Ms Katie Formston
Head of Design - Property and Capital Works
HammondCare
Level 4, 207B Pacific Highway
St Leonards NSW 2065

20 April 2020

**Redevelopment of Greenwich Hospital (Concept) (SSD-8699)
Response to Submissions**

DRAWING TITLE:
SITE ELEVATION & SECTIONS
DATE:
AUGUST 2019
DRAWN:
ML, JC
PROJ ARCH:
BF
SCALE:
As indicated @ A1
REVISION:
P5

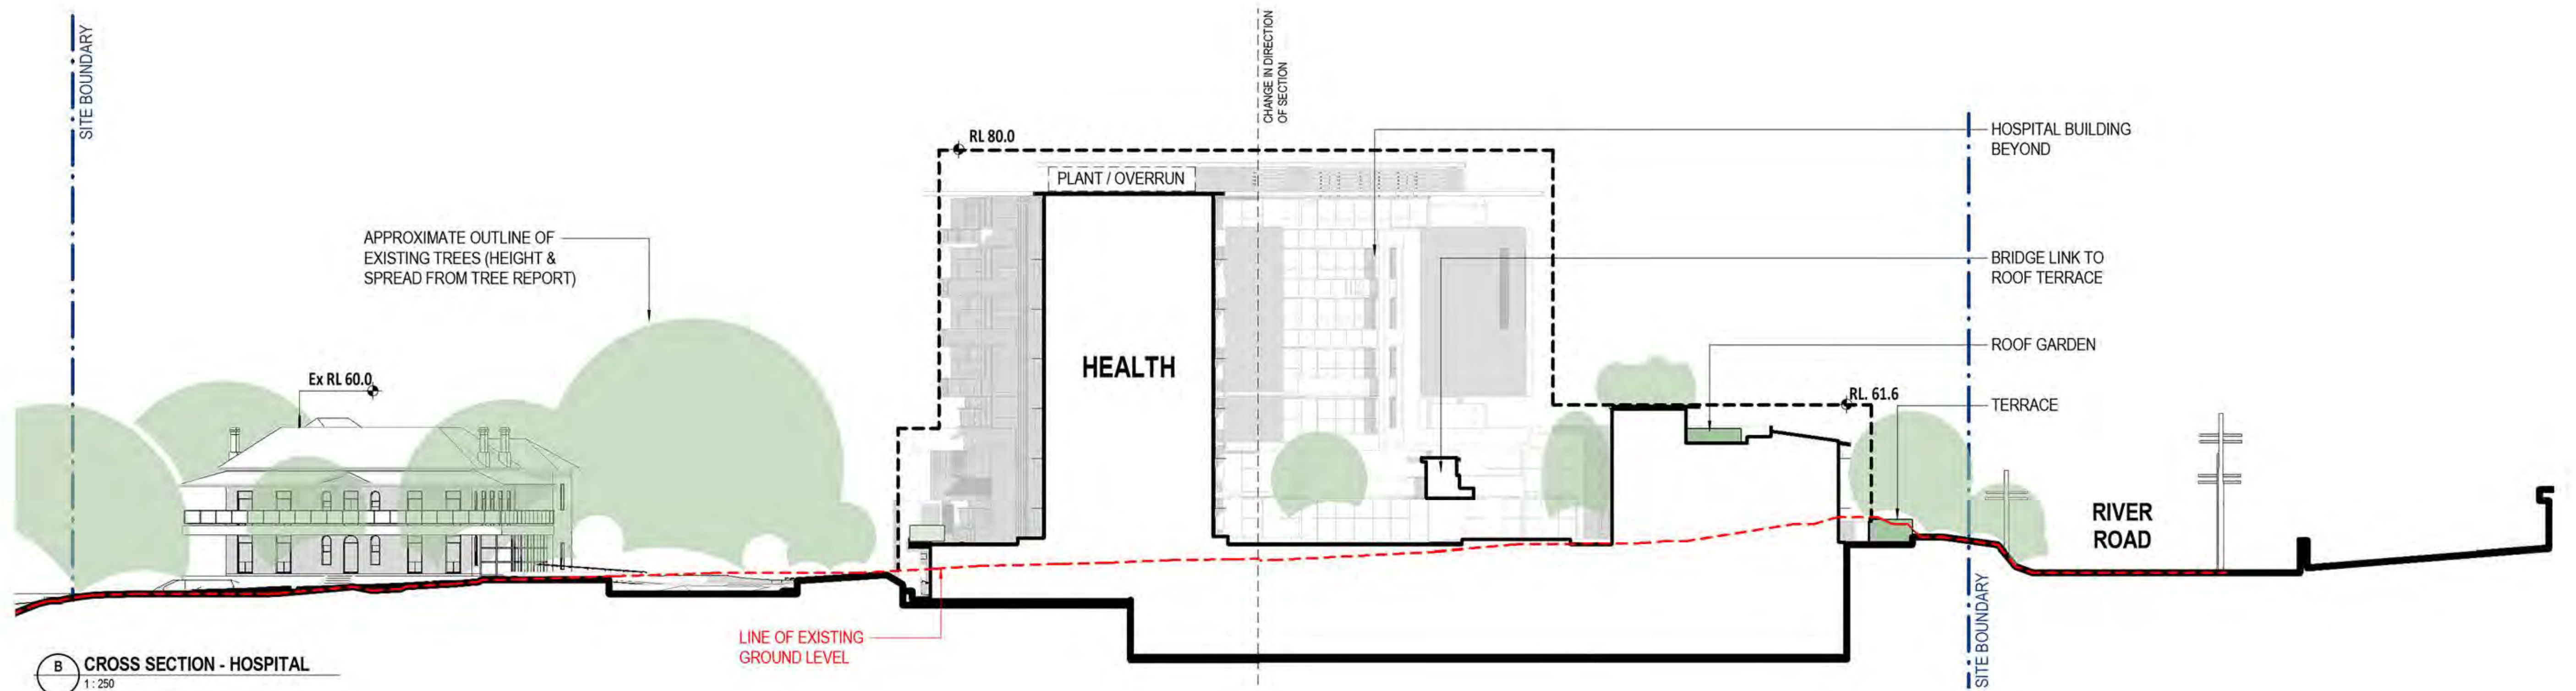
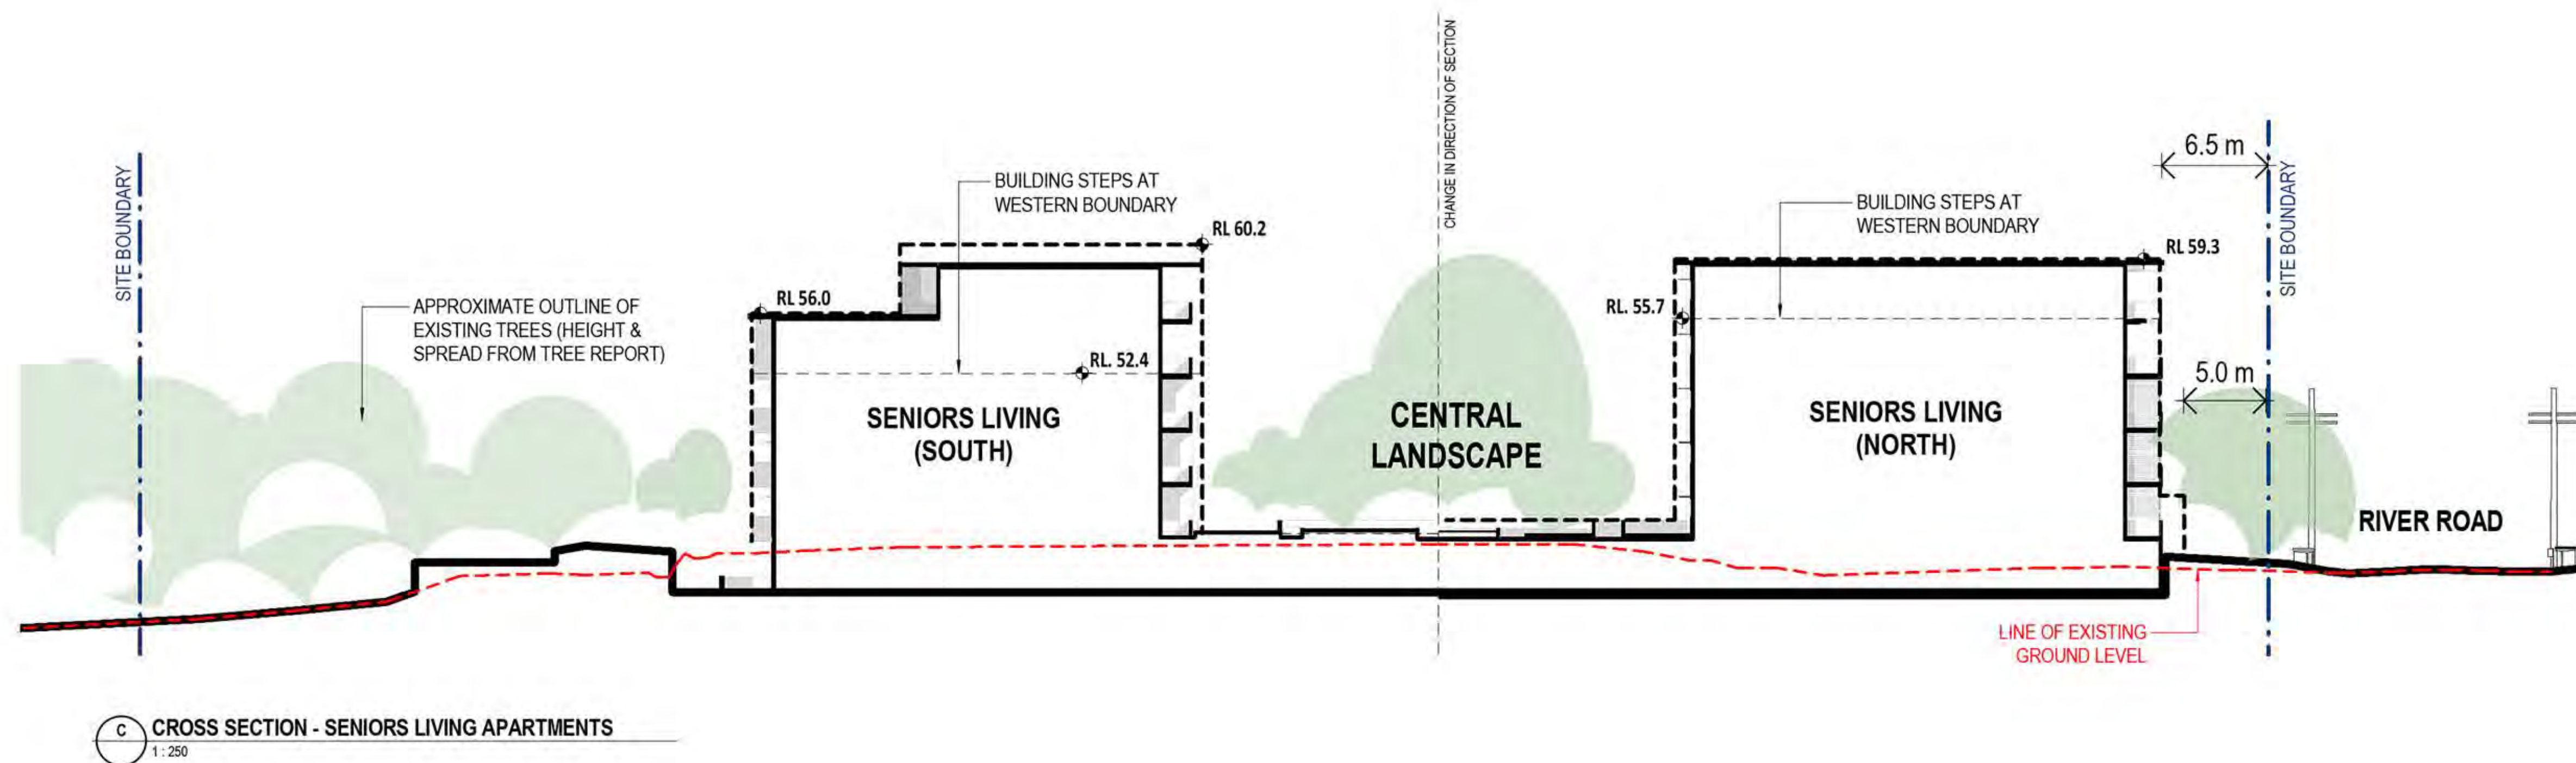
Clause 25(5)(b)(v) relates to the impact of the bulk and scale of the development. The Department considers the revised bulk and scale of the proposed seniors living apartments and on the western side of the site and the proposed hospital continues to be inconsistent with the generally low density residential character of the area. Further, the height of the proposed buildings still continues to result in a significant visual impact from across the valley to the west.

To satisfy clause 29, the Department considers the extent of seniors living on the site should be decreased, which would reduce vegetation removal, visual impacts, and provide space for the hospital to be accommodated in a building of reduced height and visual prominence.

DRAWING TITLE:
SENIORS LIVING - SOLAR ACCESS ANALYSIS
DIAGRAM
DATE:
AUGUST 2019
DRAWN:
CM
PROJ:
1213
PROJ ARCH:
BF
DRAWING:
IN.40
SCALE:
As indicated @ A1
REVISION:
P6

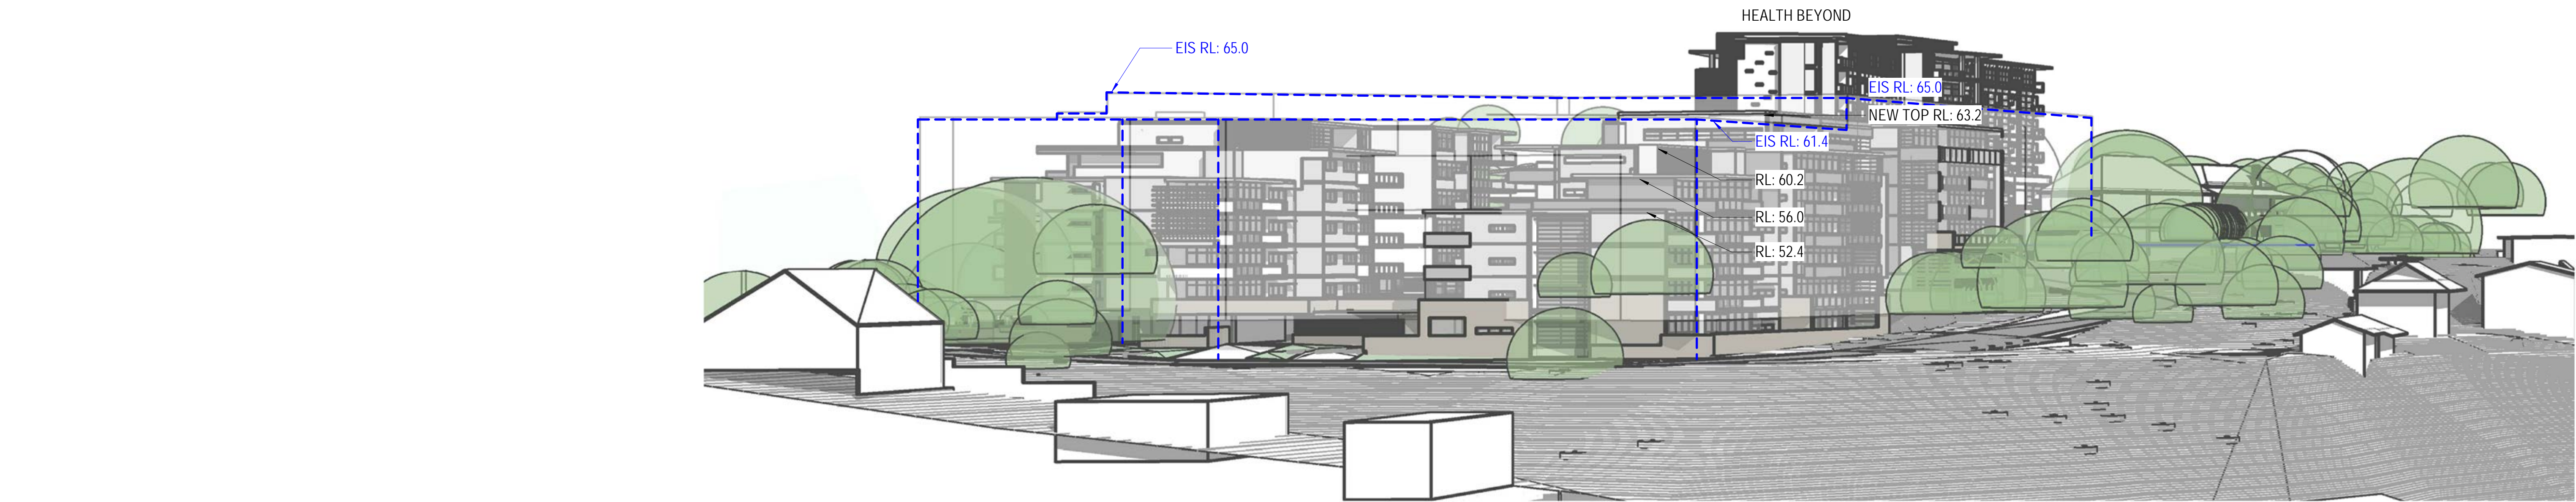
The RtS asserts that the 70 per cent of dwellings will receive three hours of direct sunlight mid-winter due to the siting and location of the proposed buildings. The details of the solar access modelling that is identified in the RtS must be provided to demonstrate how solar access would be achieved.
